Application number: 2025/93149	
What is the application for?:	Variation of condition 2 (plans) on previous permission 2024/92589 for erection
Address of the site or building:	16, Harvey Royd, Almondbury, Huddersfield, HD5 8SP
Postcode:	HD5 8SP

**PROPOSED ROOF PLAN**  
SCALE 1:100 @ A1

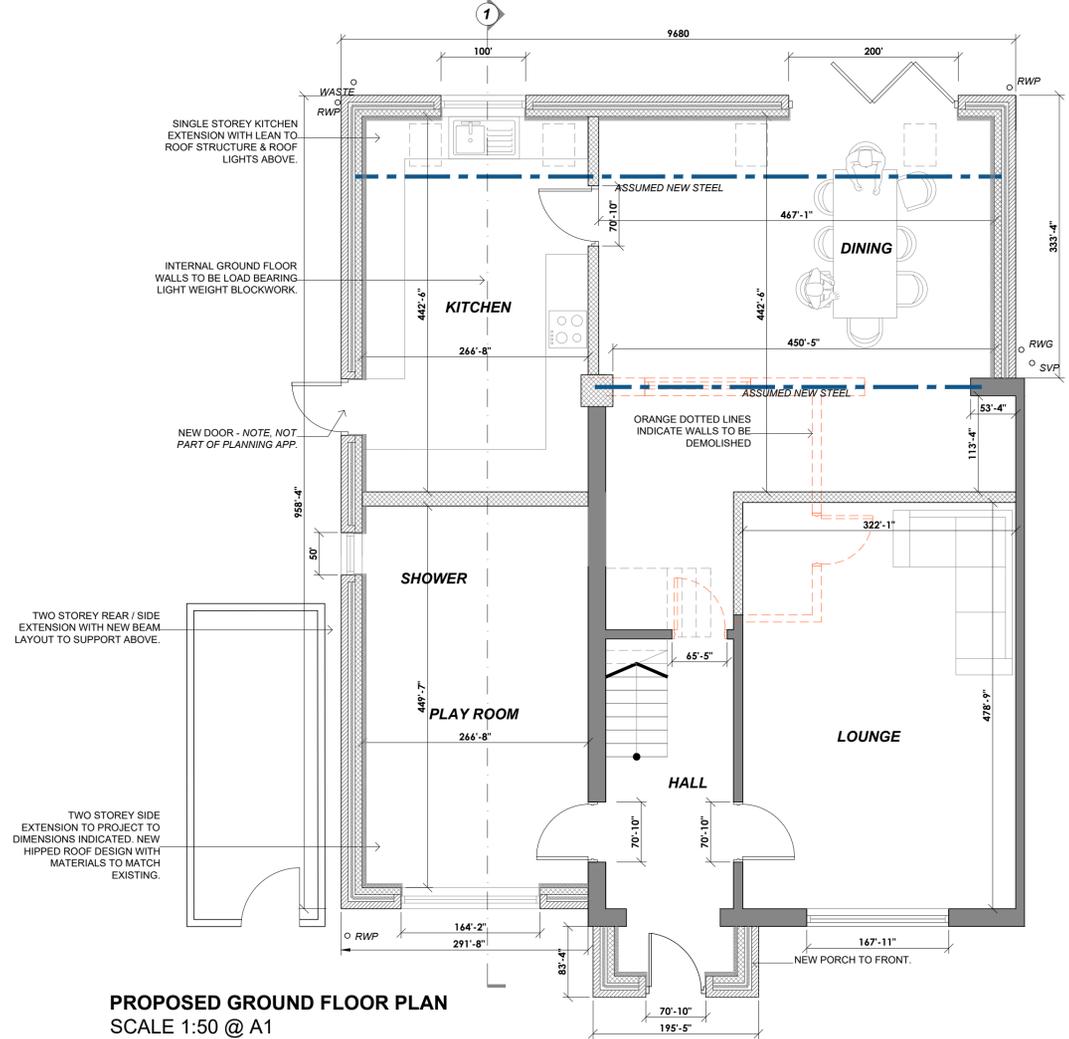
Type of comment: An objection	
Do you wish your comments to be published on the website anonymously?	Yes
<p>I am a resident living on Aldonley. From our rear patio, we can see the extension directly opposite us. In my (professional) opinion the side elevation has been built too high and should be reduced. Am I right in saying that there was an enforcement notice on the works, that is why a second application has been submitted?</p> <p>The wall (side elevation) is too high. If these works are to proceed, then the height of the side elevation wall should be no higher than the height of the eaves of the existing building (so that the gutter continues all around). In addition, the roof should be hipped to match the existing hip on the existing dwelling.</p>
